Our ref: SSD 5169 MOD2, 12/03480

**Horsley Drive Business Park Subdivision and Infrastructure Works (SSD 5169) – MOD2  
Response to Submissions**

**HORSLEY DRIVE BUSINESS PARK – SSD 5169 MO1– REQUEST FOR MODIFICATION**

SECTION CC - The Horsley Drive  
1:200

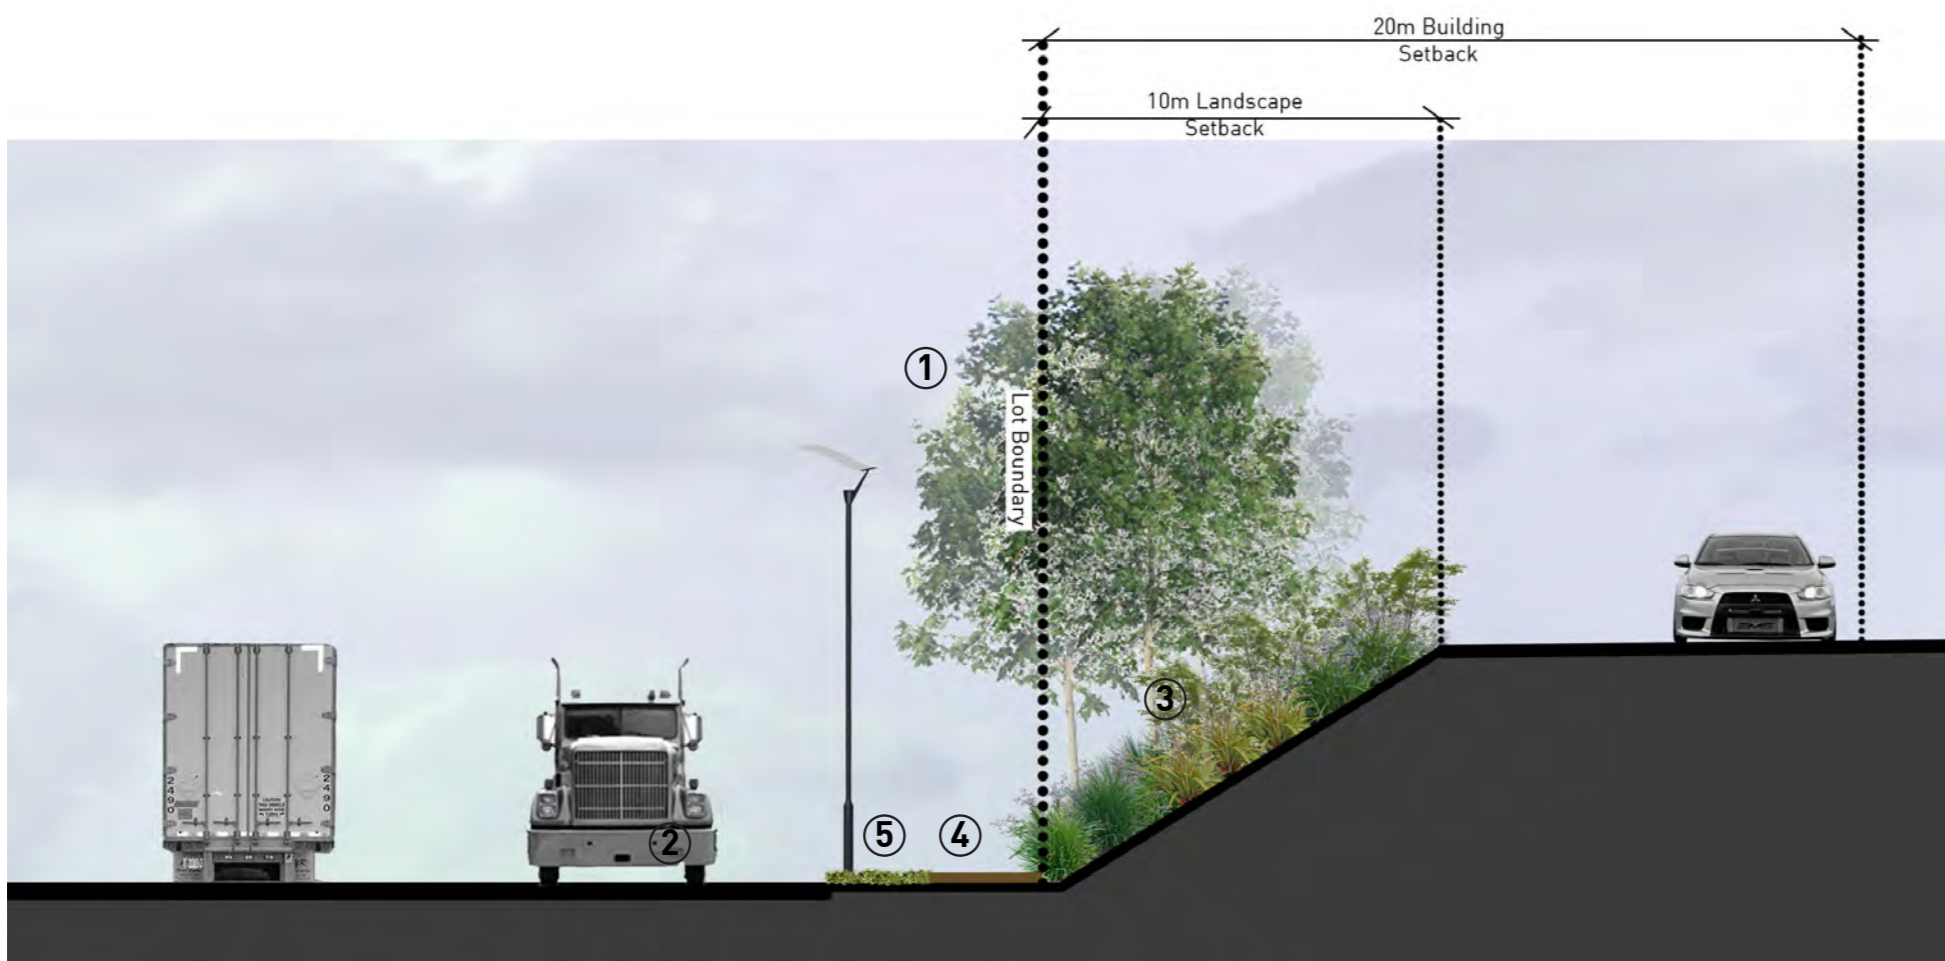
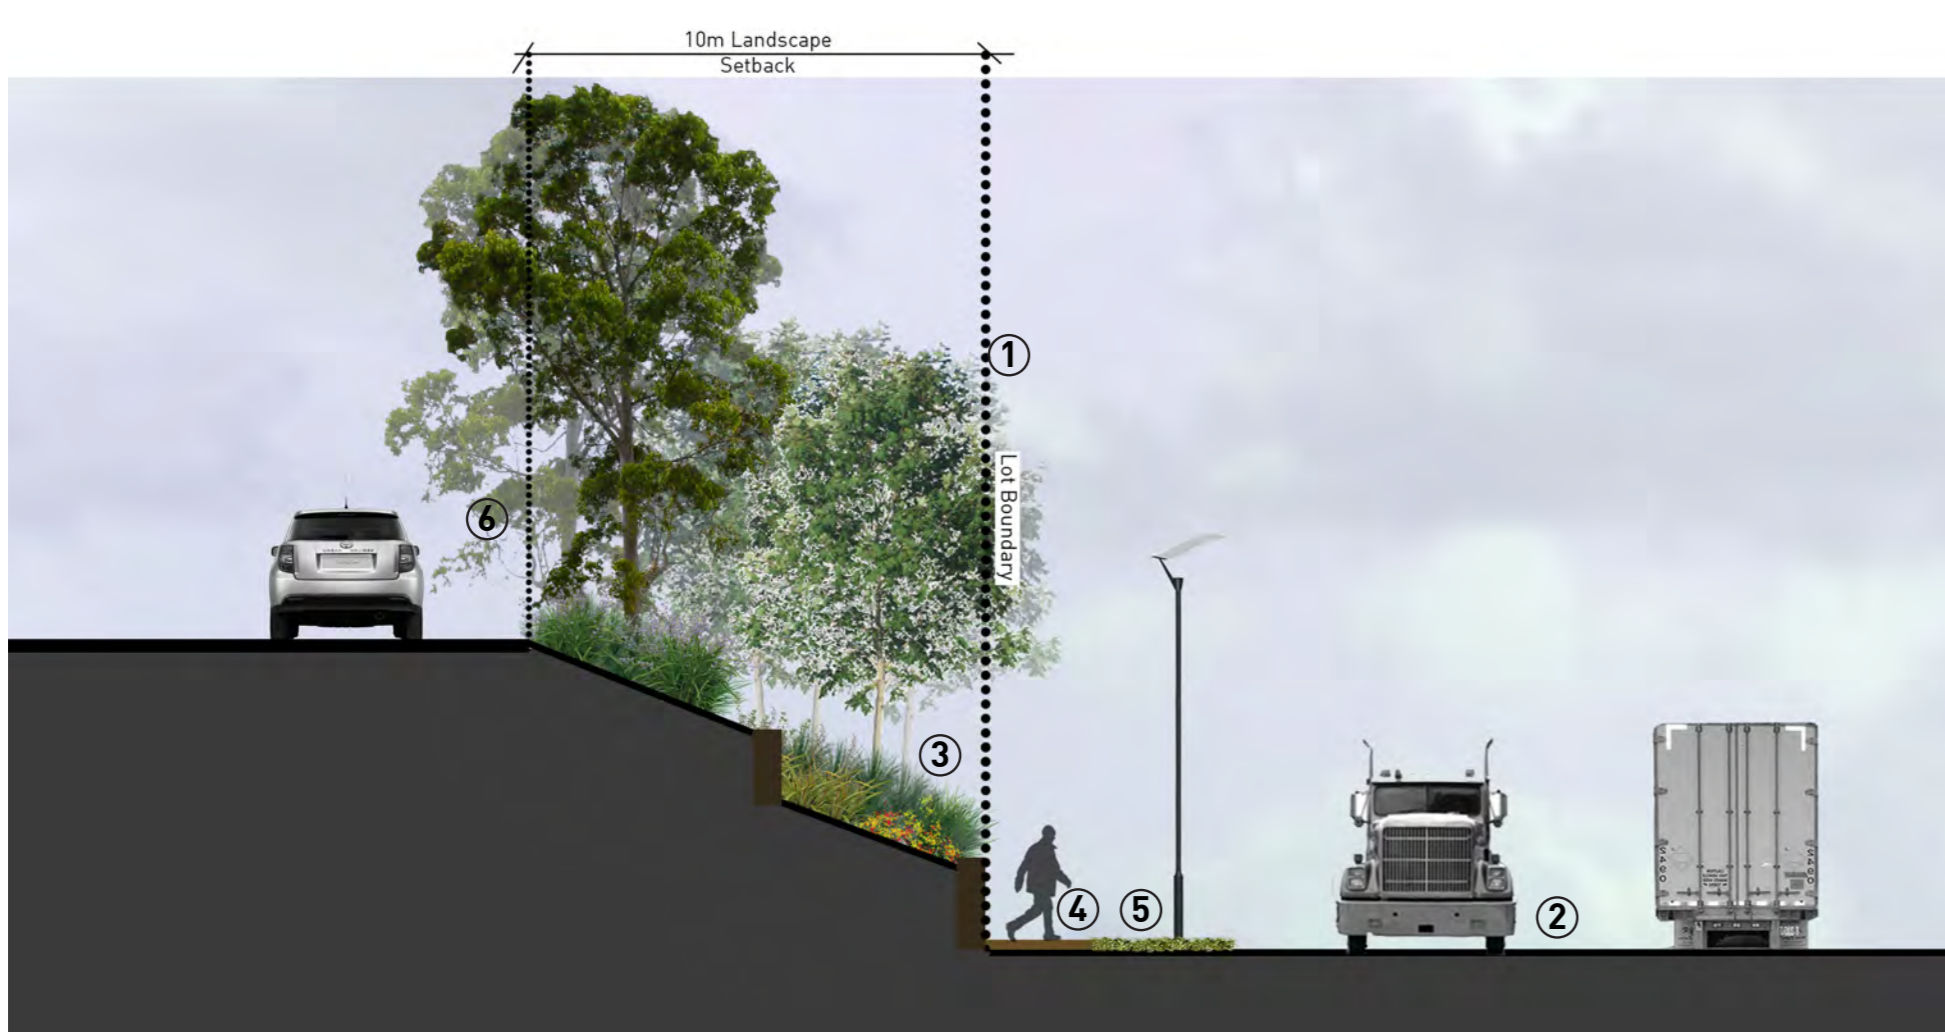
The landscape plans do not assist in satisfying the Department's streetscape concerns. No elevations to either The Horsley Drive or the Cowpasture Road have been provided. An additional section closer to the corner of The Horsley Drive and Cowpasture Road, where the retaining walls would appear to attain their maximum height, is requested in order to assist the Department's assessment of this issue.
